From: Sue Howell <Sue.Howell@arun.gov.uk>
Sent: 21 April 2022 15:41
To: Planning.Responses <Planning.Responses@arun.gov.uk>
Cc: Simon Davis <Simon.Davis@arun.gov.uk>
Subject: Planning Consultation on: BR/38/22/PL

Application ref: BR/38/22/PL

Location: 18-20 London Road Bognor Regis PO21 1PY

Summary recommendation: Recommend **no landscape objection** to the proposals.

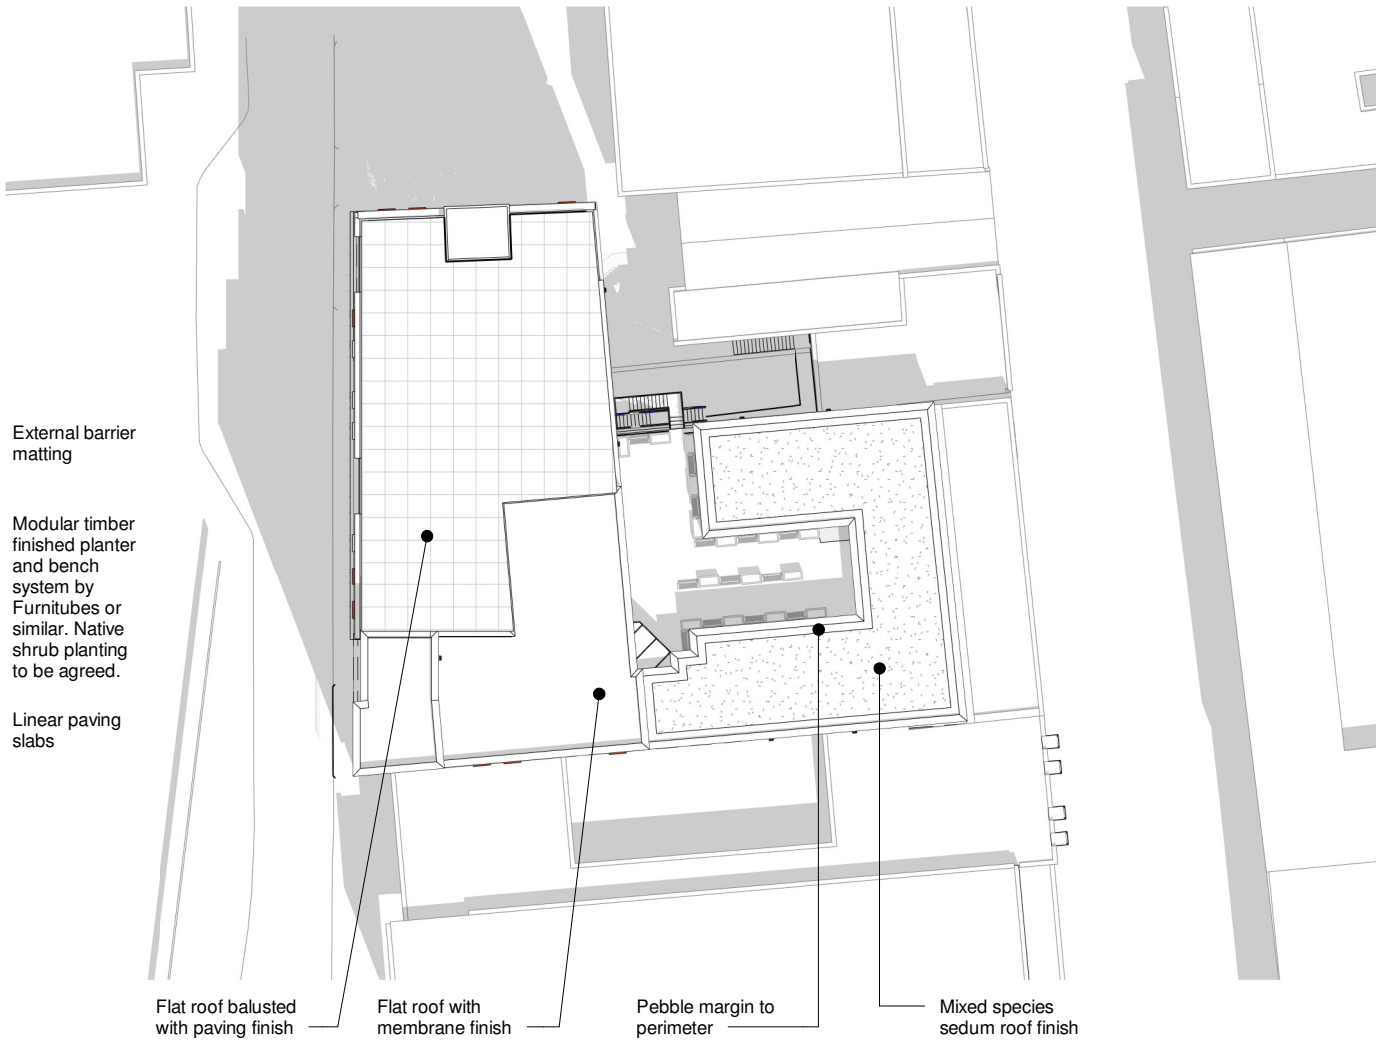
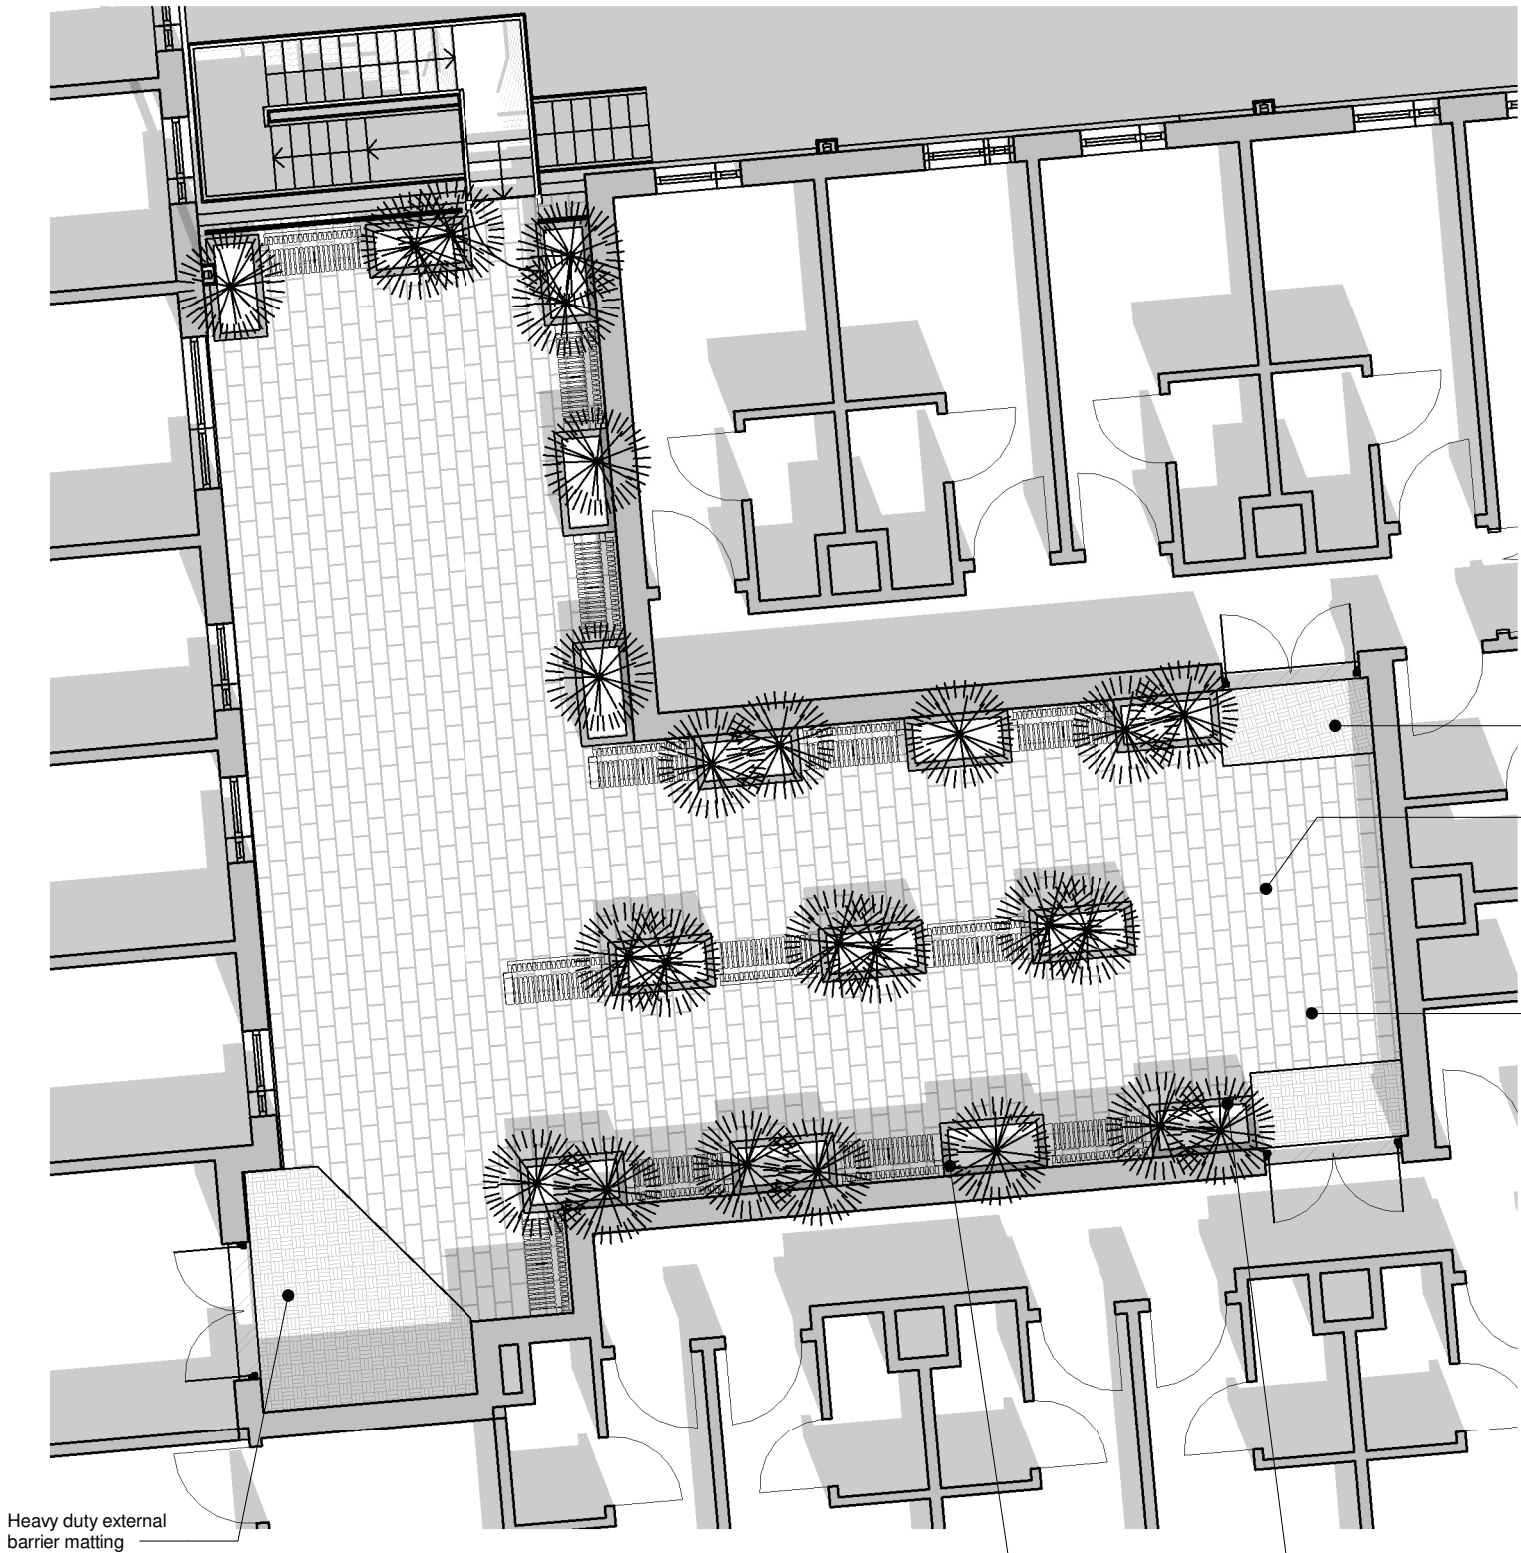
The proposed landscape plan dwg 16102 P620 Rev P1 indicates a roof terrace with modular timber raised planters, further detail would be required re the specification and planting detail for these.
